## 203 Fore Street Tree & Landscape

Jeff Tarling <[jst@portlandmaine.gov](mailto:jst@portlandmaine.gov)>

Fri, Jan 5, 2018 at 3:59 PM

SITE PLAN LEVEL 02 - MIDDLE STREET  
 1/16" = 1'-0"

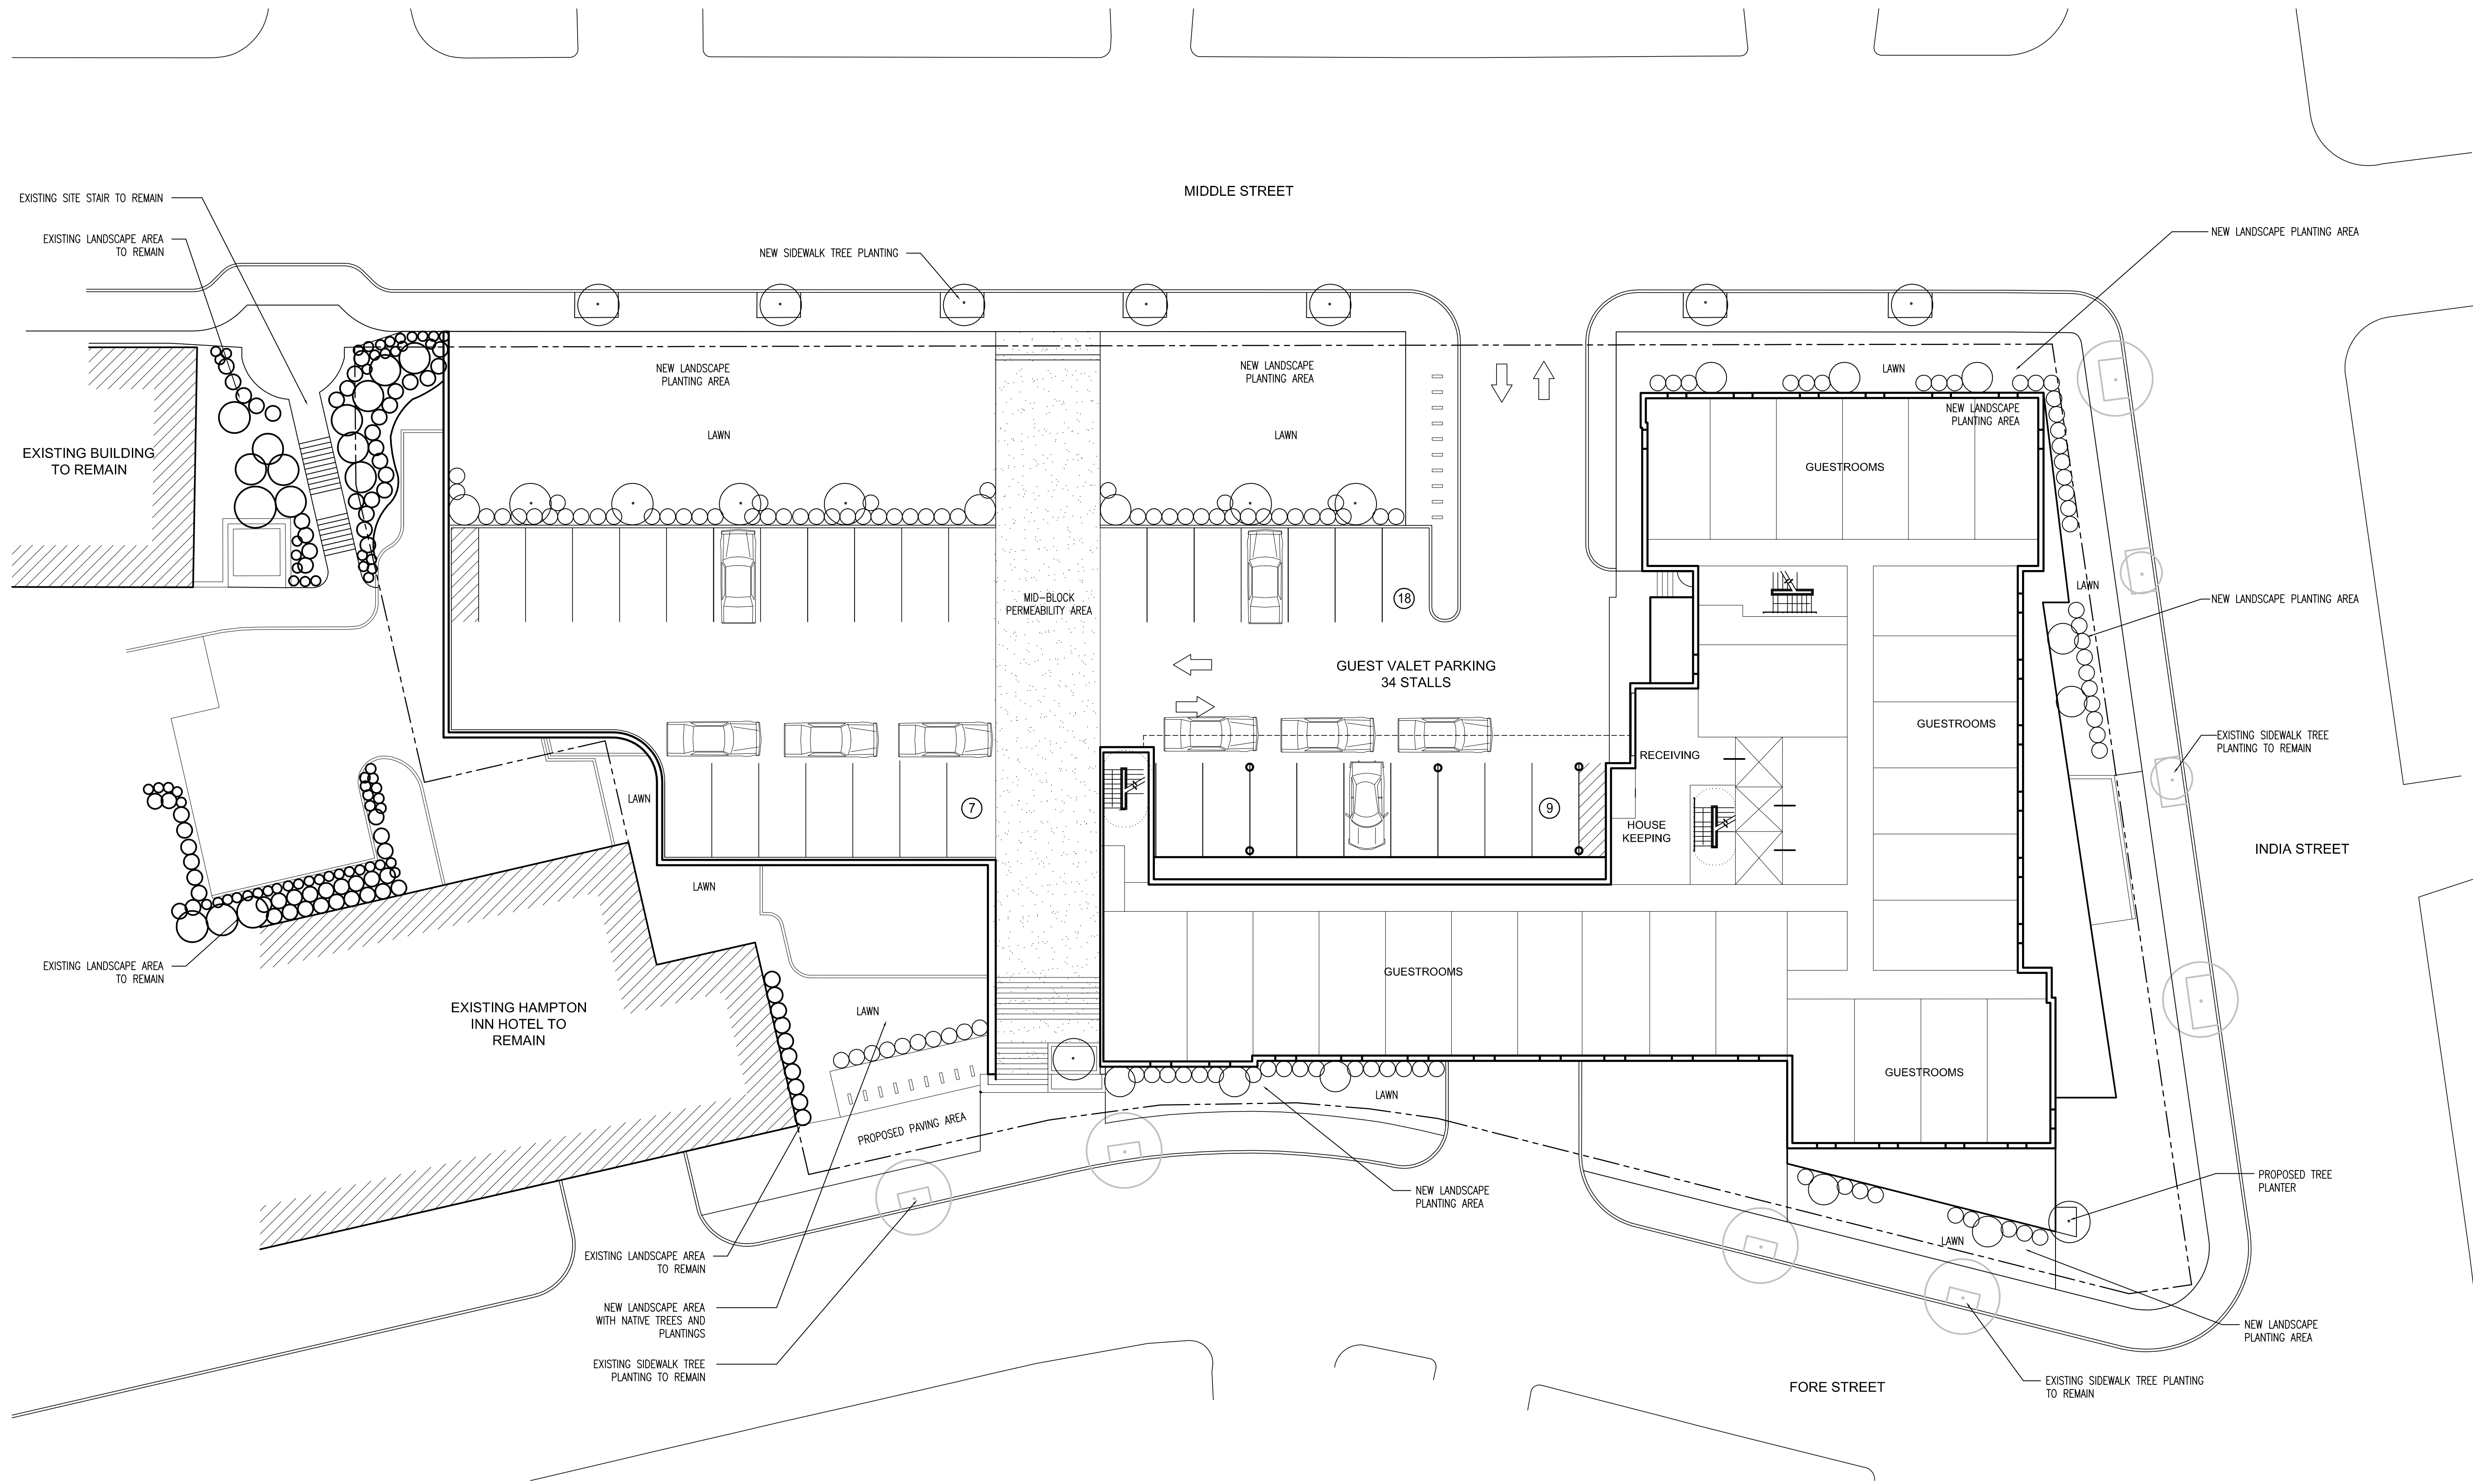
Wanted to see if we could interface with the project team about the tree and landscape aspects of their plan. Are they including a more defined plant list? And, did not see adequate inclusion on the India Street frontage, we would want to see new Street-trees along India Street that were paused when the earlier Hampton Inn project was presented.
